Application by Highways England for A47 Wansford to Sutton Dualling

The Examining Authority's written questions and requests for information (ExQ1)

Issued on 16 December 2021

DRAWING TITLE  
**RIGHTS OF WAY AND ACCESS PLANS  
REGULATION 5(2)(k) and 5(2)(o)  
SHEET 5 OF 7**

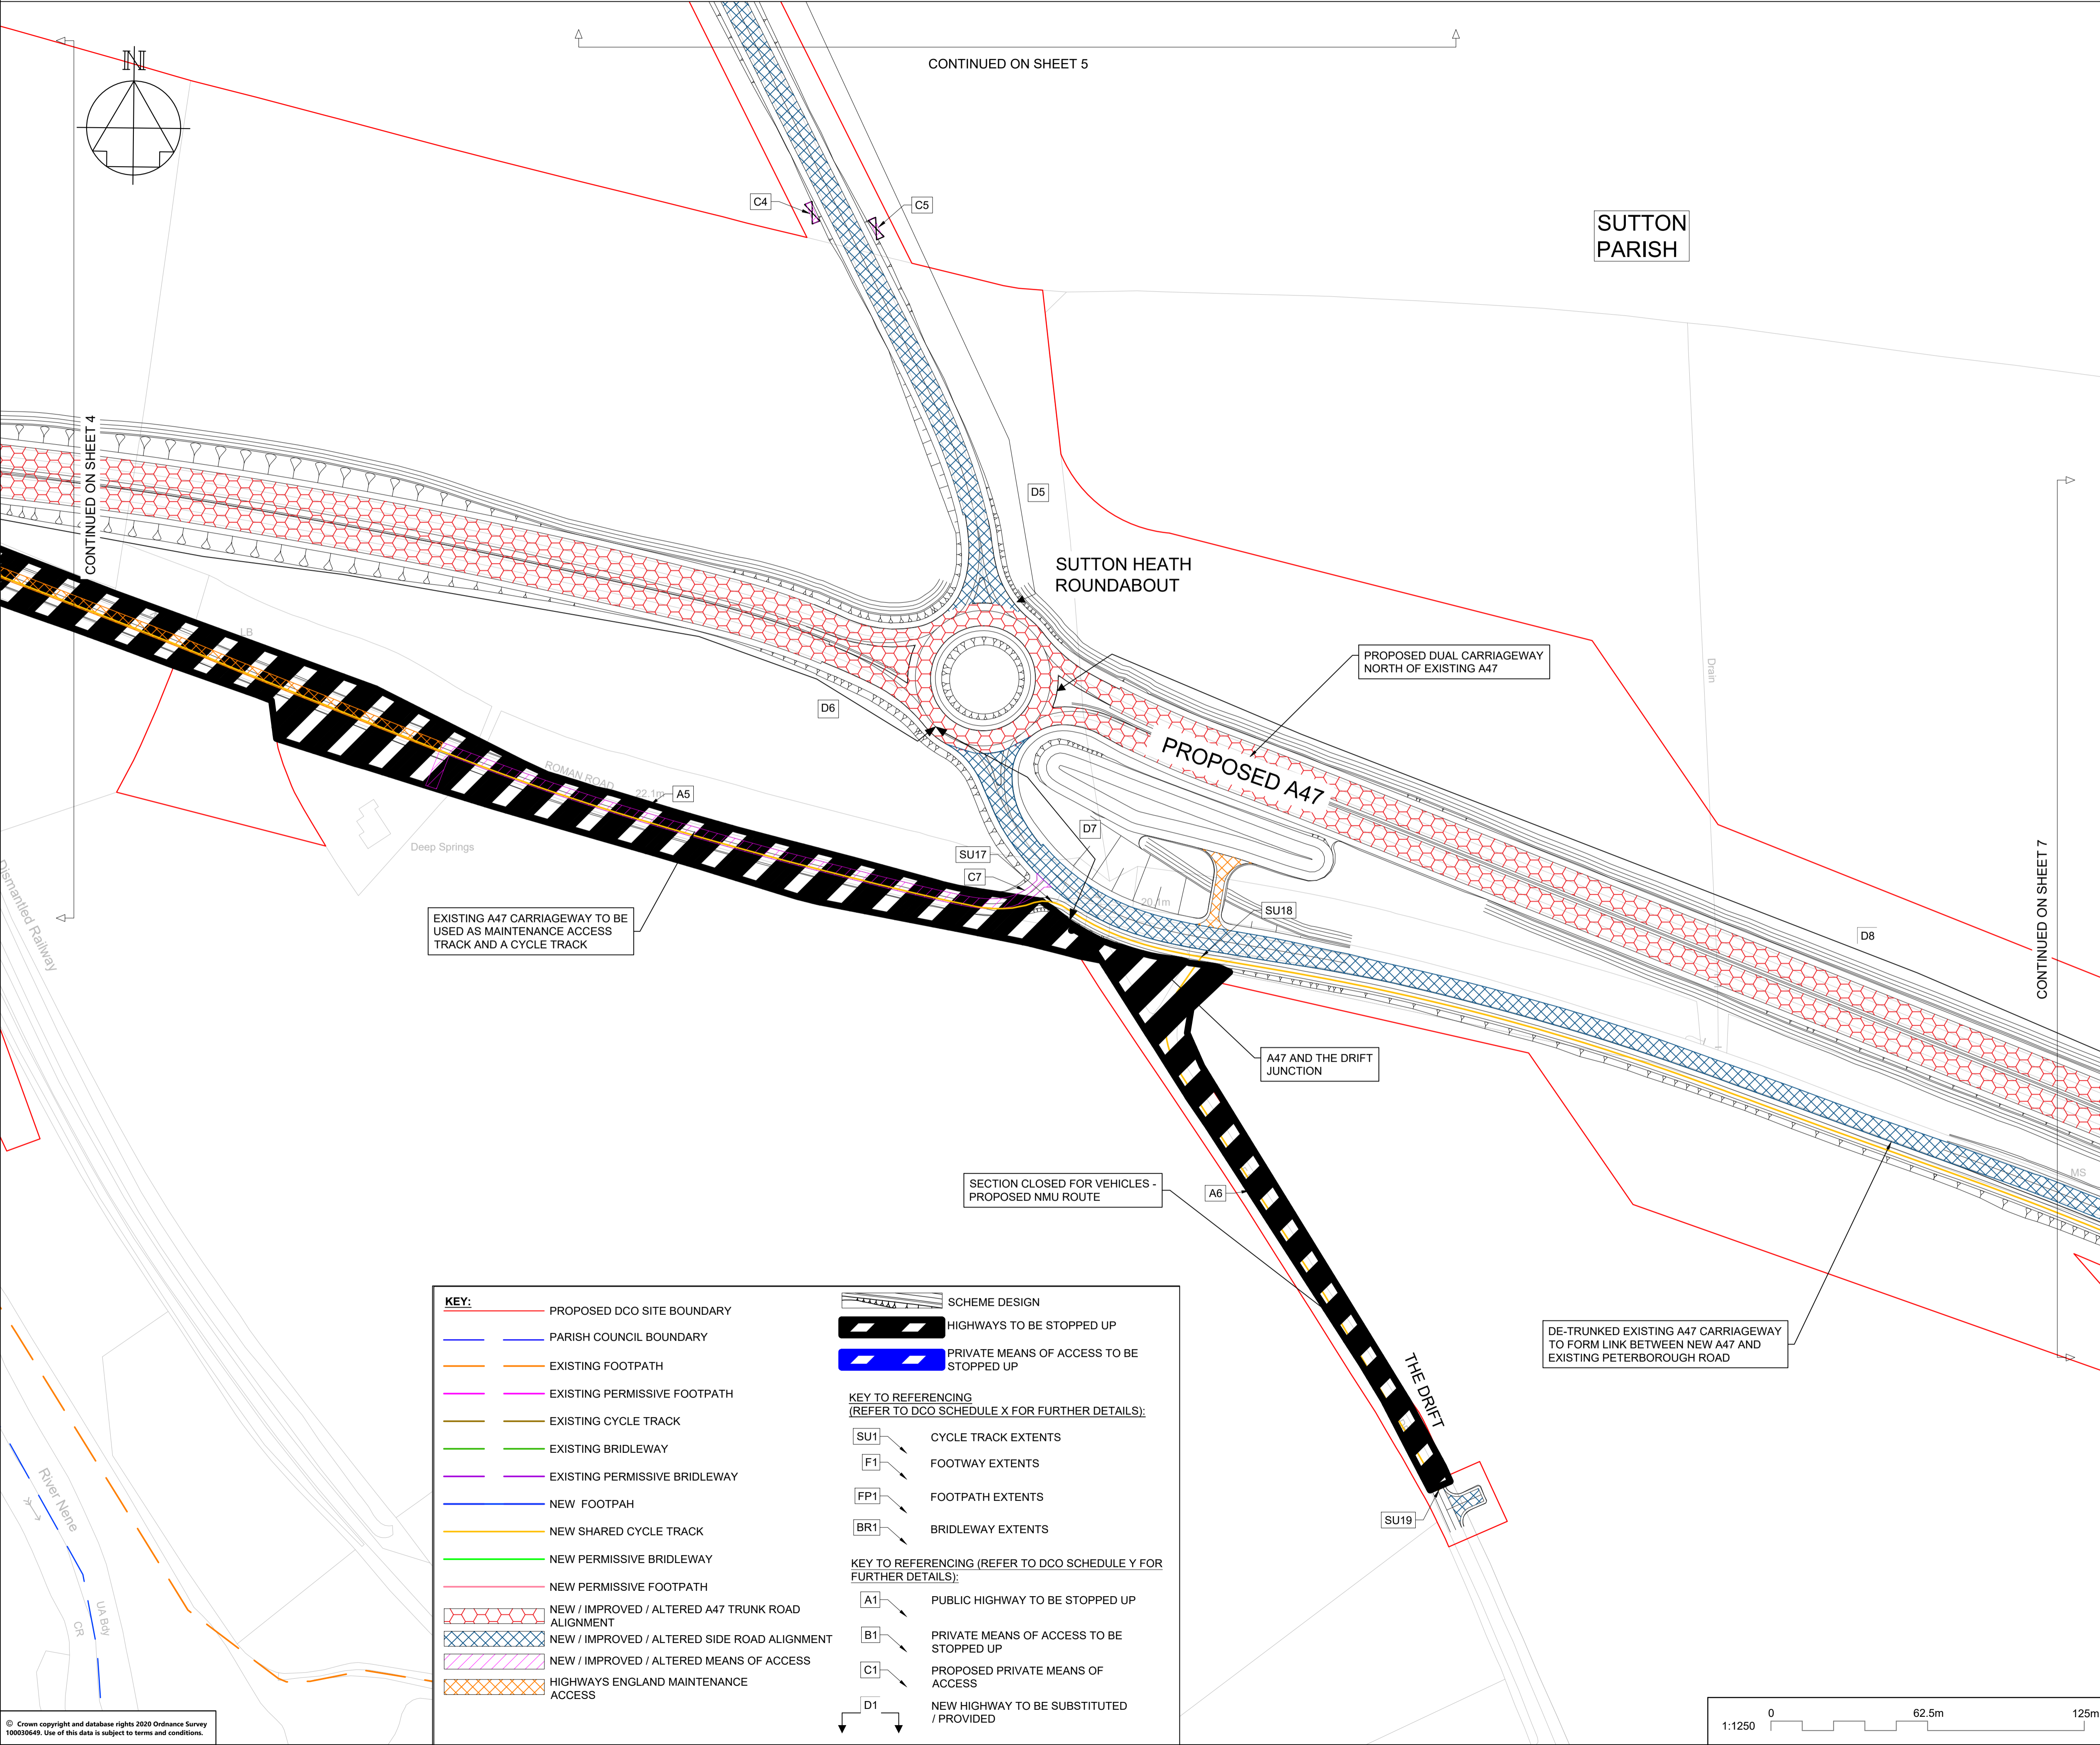
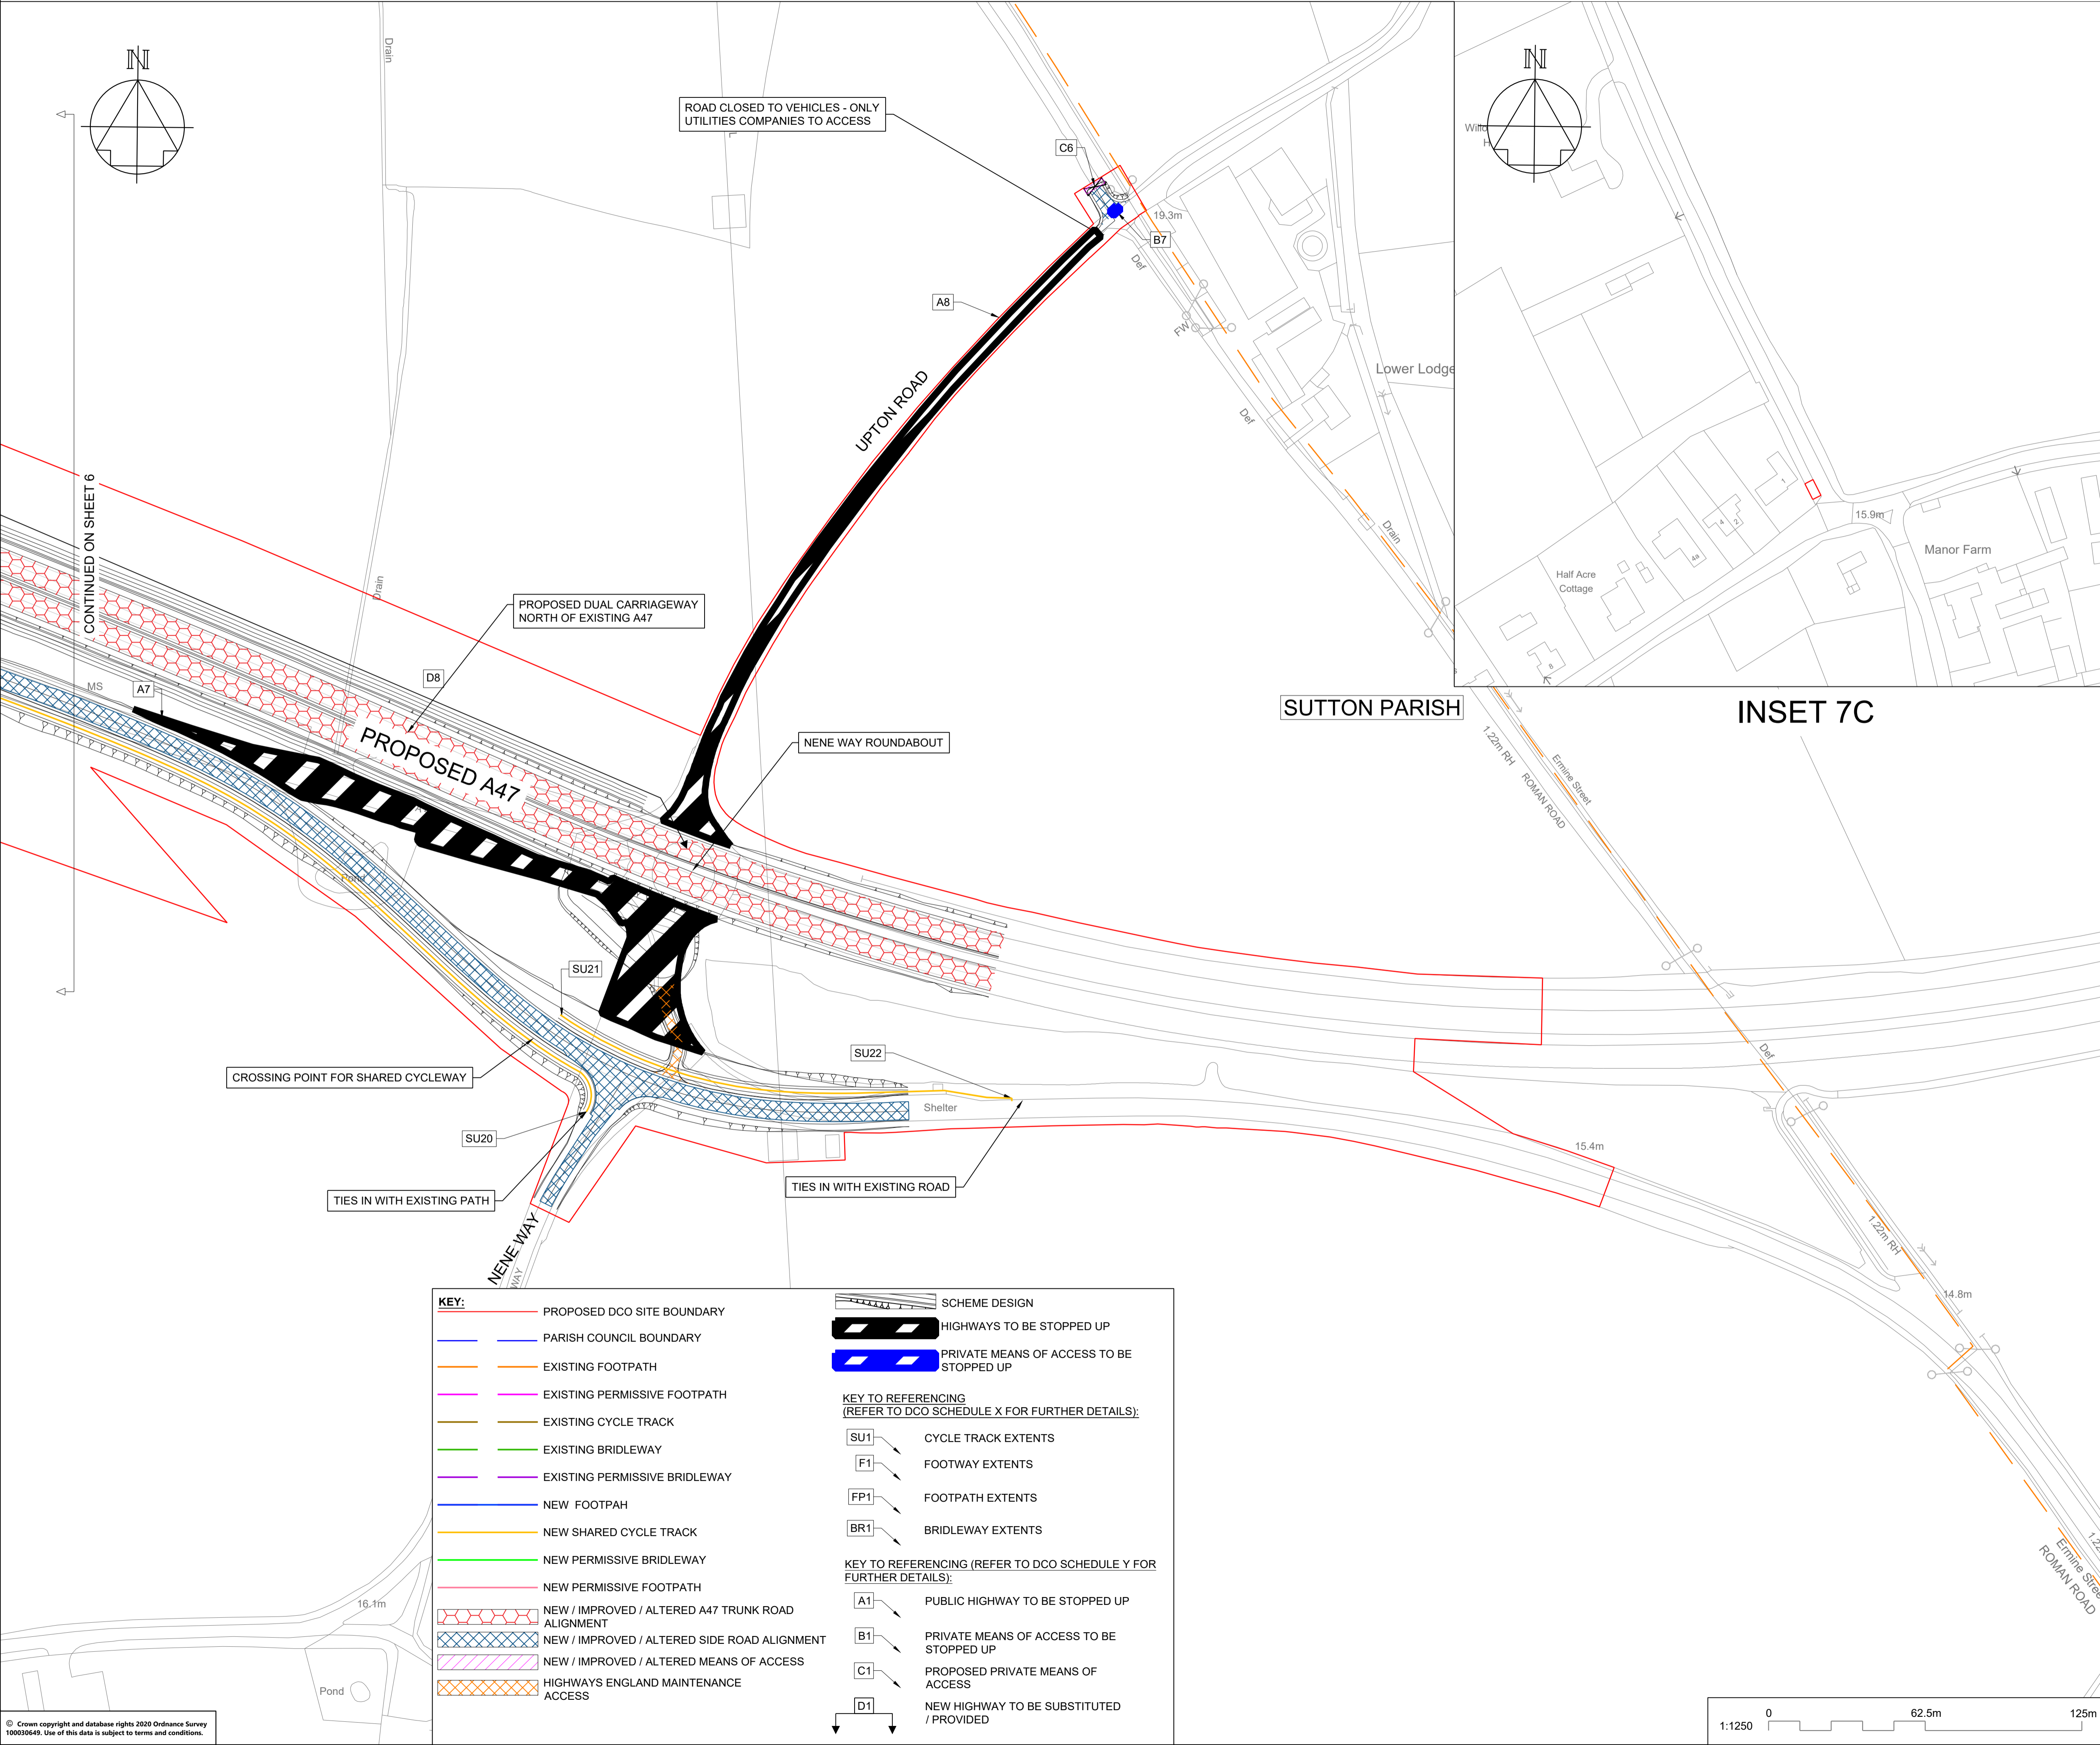
1.0.8.	The Applicant	Rights of Way and Access Plans a) Key has Schedule X and Y – please amend. b) Some drawings are titled “Rights of Way and Access Plans” and other “Public Rights of Way and Access Plans” – is there a reason for this or should/ can this please be made consistent?
